Your ref
Our ref TL /3/2013/0981
Date 3rd January 2014

Planning application no: 3/2013/0981.

Proposal: Outline Application for residential development comprising 20 dwellings (including 6 units of social housing), 3 units of close care apartments and a 60 bed care home (all matters reserved for subsequent approval).

Location: Land at Chatburn Road, Clitheroe.

#### 4. CHATBURN ROAD/PIMLICO LINK ROAD REVIEW

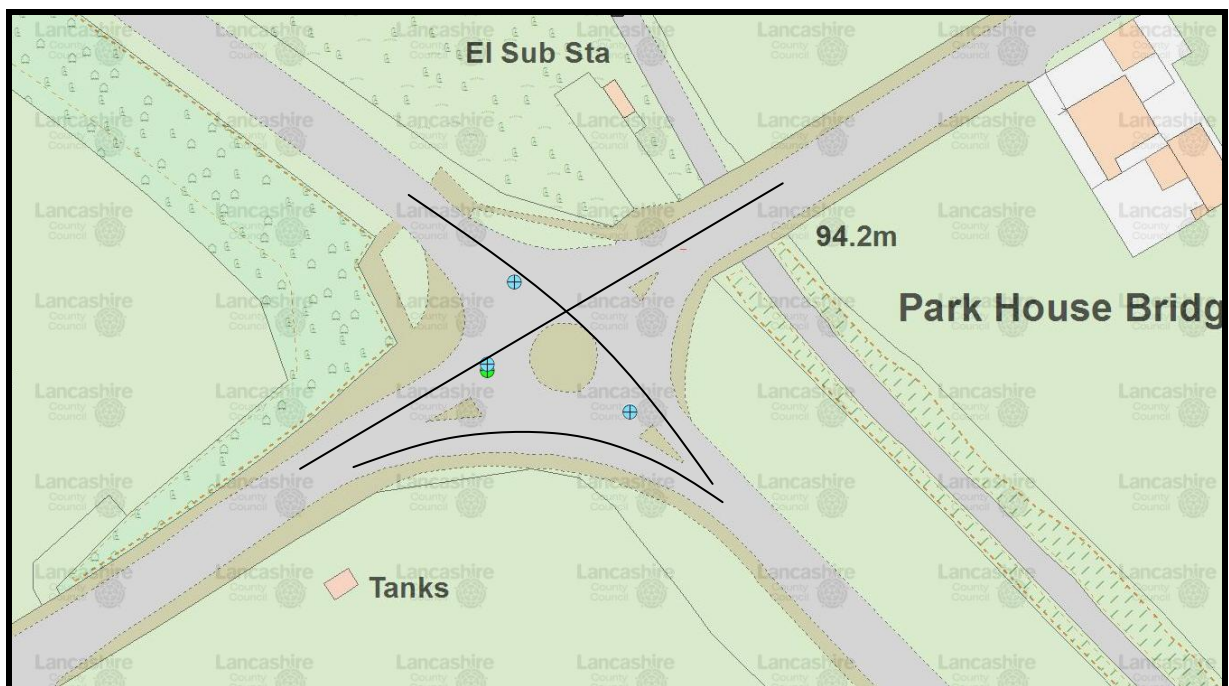
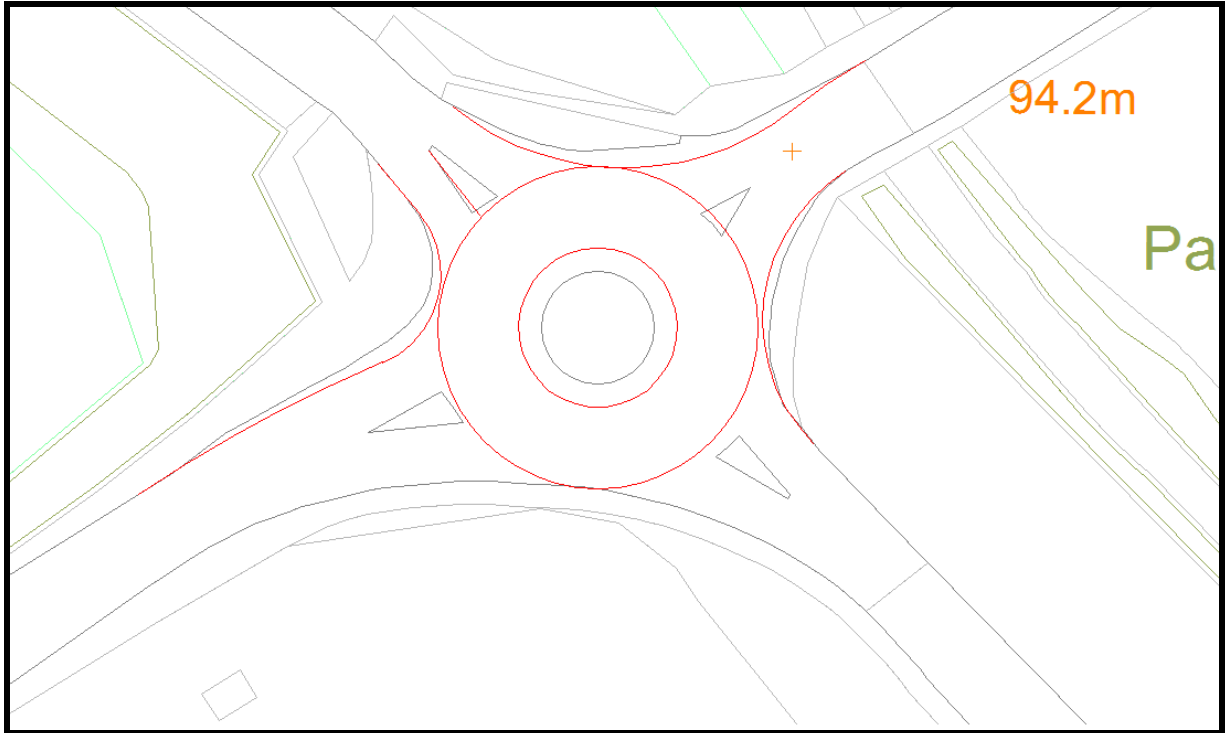
The transport statement has reviewed the design of the roundabout at the Chatburn Road, Pimlico Link road junction, and has recommended improvements to the geometry of this roundabout. The improvement to the roundabout is accepted, although the detail of the design will have to be scrutinised by LCC engineers and a safety audit should be carried out. This work would be carried out under a section 278 agreement.
